From  
THE SECRETARY,  
General Metropolitan  
Development Authority,  
No. 5, Gandhi Memorial Road,  
Chennai- 600 028.

Letter No. 32/10001/88

Sub. CM&A - AP - FF - Construction of Part Villa + 4 Floors and Part Ground Floor + 3 Floor building for 7 dwelling units at Plot No. 2, Crescent Road, Sherry Nagar in S. 20-24/1 & 40% of Peripetoidal Village - Possessions of S.O. and other charges - Proposed - Regarding.

B/26232/388 P/S/88
APPROVED
 SUBJECT TO THE CONDITIONS IN THIS OFFICE LETTER
 No. B/18733/88 Date 12-5-88
 FOR THE SECRETARY
 CHENNAI METROPOLITAN
 DEVELOPMENT AUTHORITY
 CHENNAI-600 008.

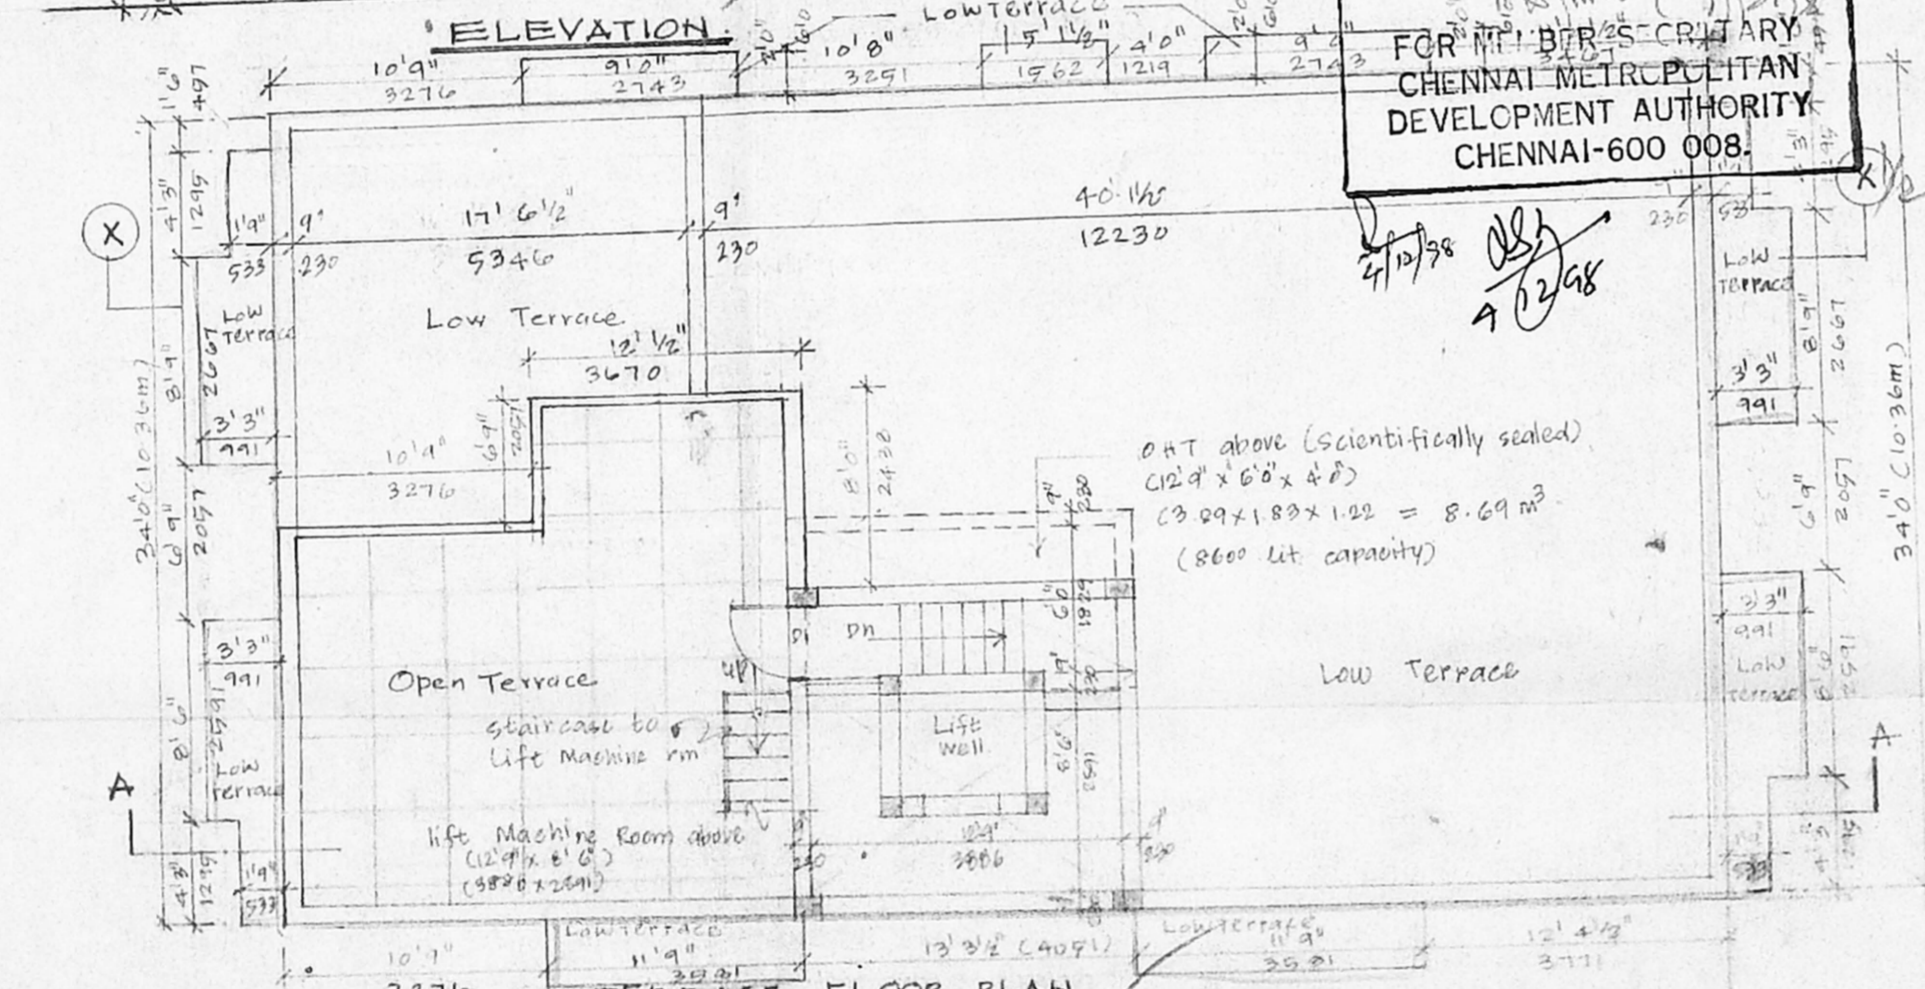
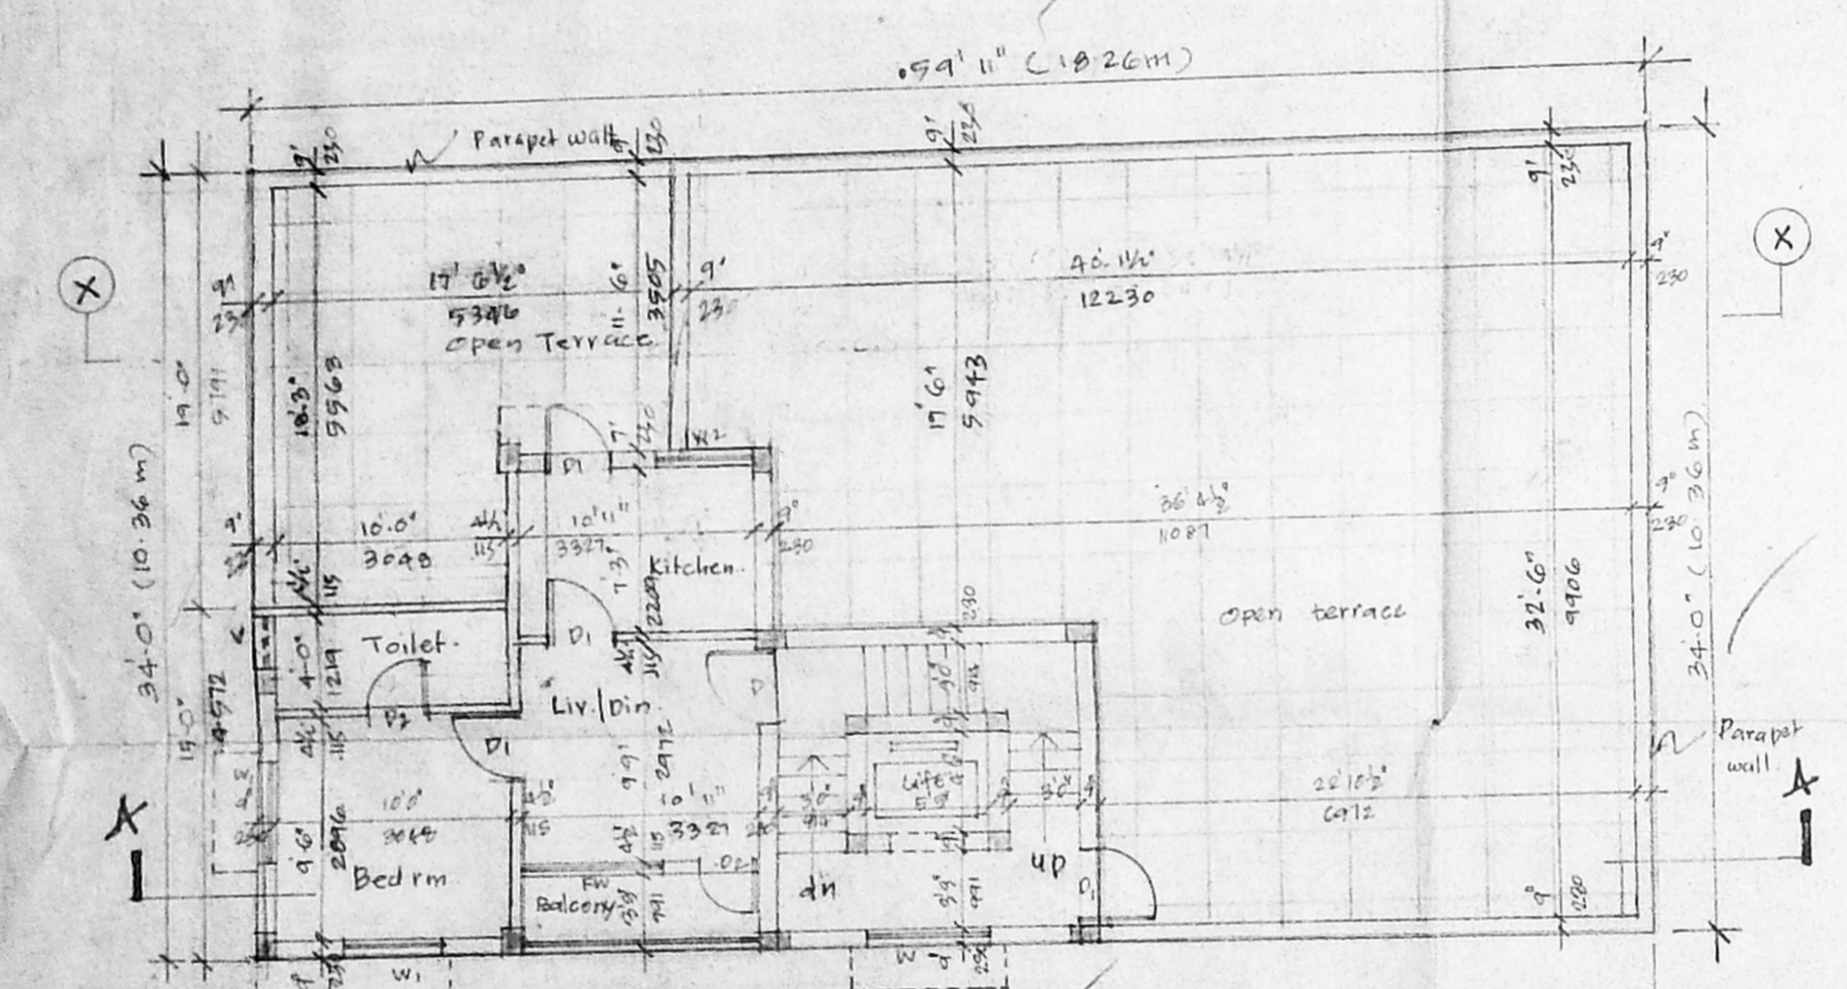
- 111.(c) You are requested to furnish five copies of revised plans complying with the following :-
  - (i) French window for the 2nd floor at 2nd and 3rd floor to be converted as ordinary window.
  - (ii) The floor level of stilt floor to be increased by 1'-0" from ground level and providing ramp at the stilt parking area.
  - (iii) Rain Water trench to be provided on south side also as provision of dummy slab may not be feasible.
  - (iv) Balcony & wardrobe projections to be indicated in site plan.
